Recommendation Report for Planning Permission for Works or Extension to a Dwelling

REF NO: FP/270/21/HH

LOCATION: 21 Poulner Close
Felpham
PO22 8HN

PROPOSAL: First floor side extension over existing garage.

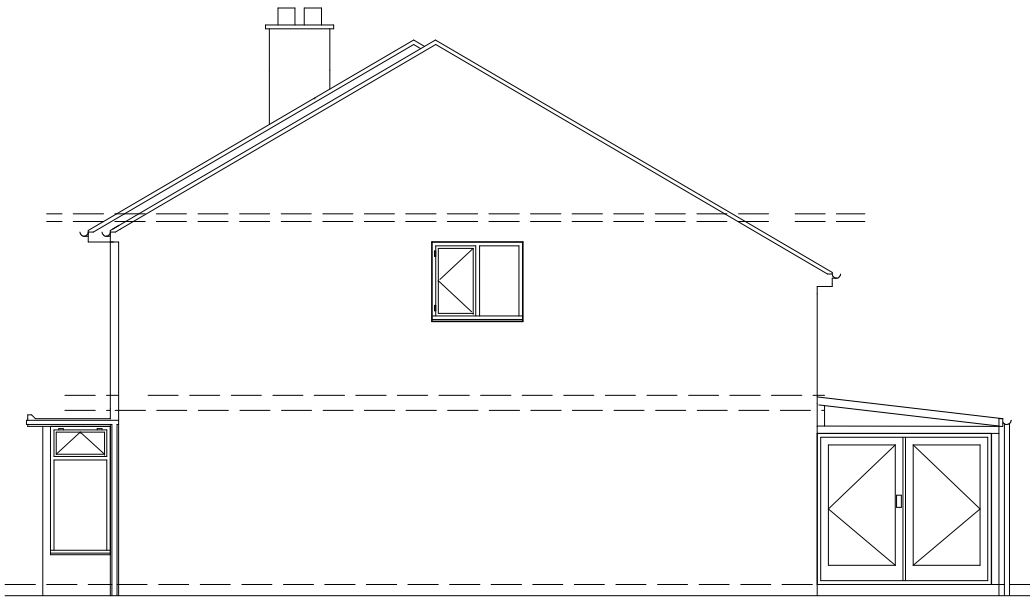
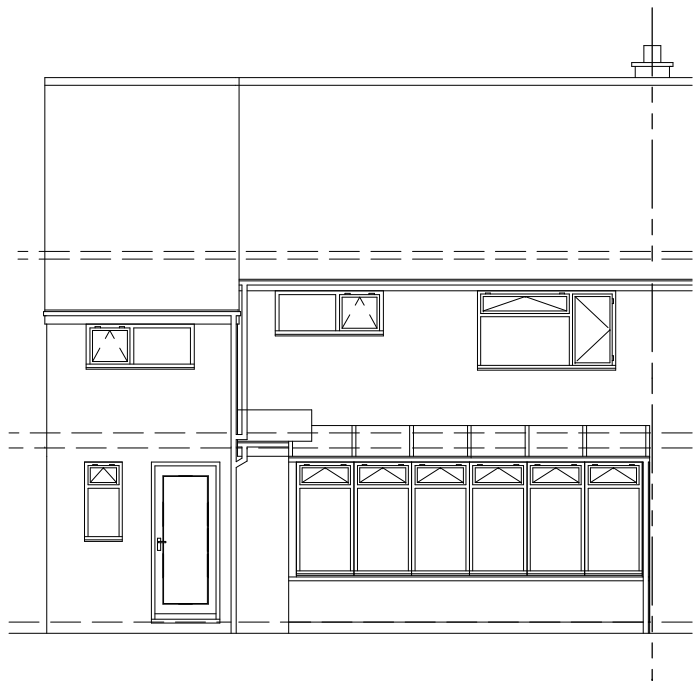
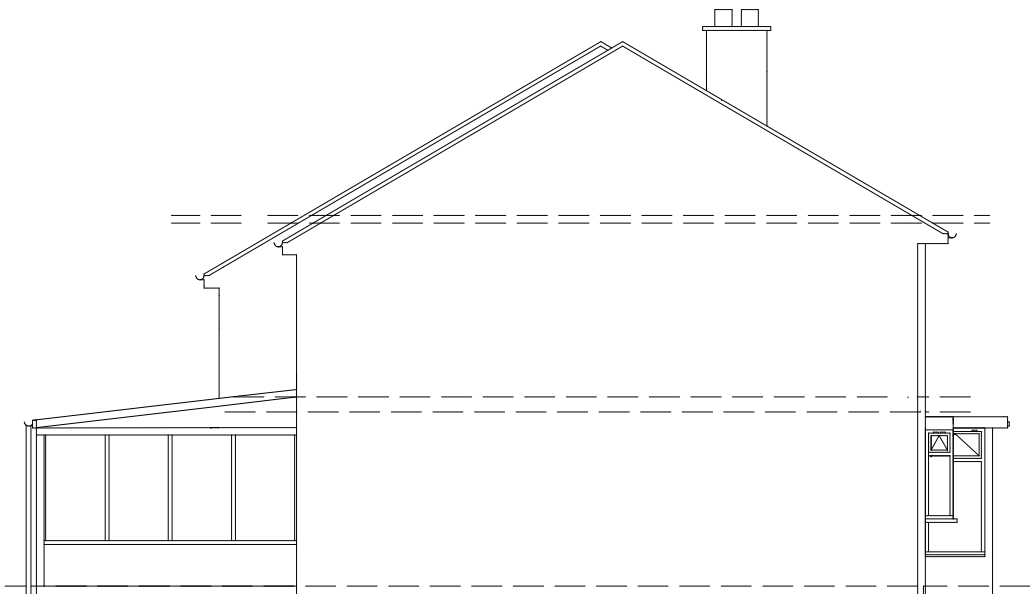
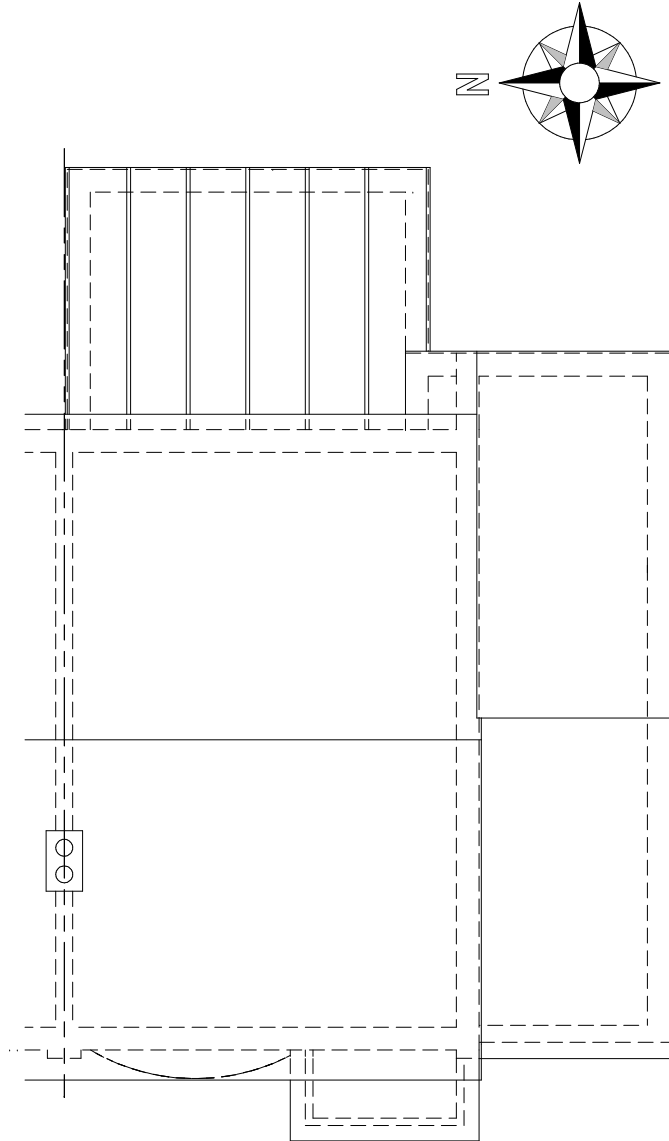
The side extension is set slightly back from the principal elevation and will meet with the ridge height of the main dwelling. This runs along the full side elevation and extends slightly beyond the rear by around 1m. The extension does propose cladding to the first floor which will be dark grey in colour. Cladding is not common in the area although its use does not result in the dwelling appearing significantly out of character with the area.

The Arun Design Guide states 'Positioning extensions below the roof ridge line of the existing property will also help to create visual subservience'. The proposal does not comply with this being the same height as the ridge although it also states 'extensions must not close important gaps in the street scene by leading to a terracing effect'. The proposal complies with this and appears appropriate in scale and massing.

The first floor would be sited above the ground floor addition matching the height of the host dwelling.

There will be an additional window to the rear although this will serve a bathroom. There will also be a bedroom window to the side elevation although this replaces an existing window and is not considered to give rise to overlooking additional to that which exists. Due to the siting and the angle of views available, it is not considered views upon the rear garden of the property at No.23 are achievable.
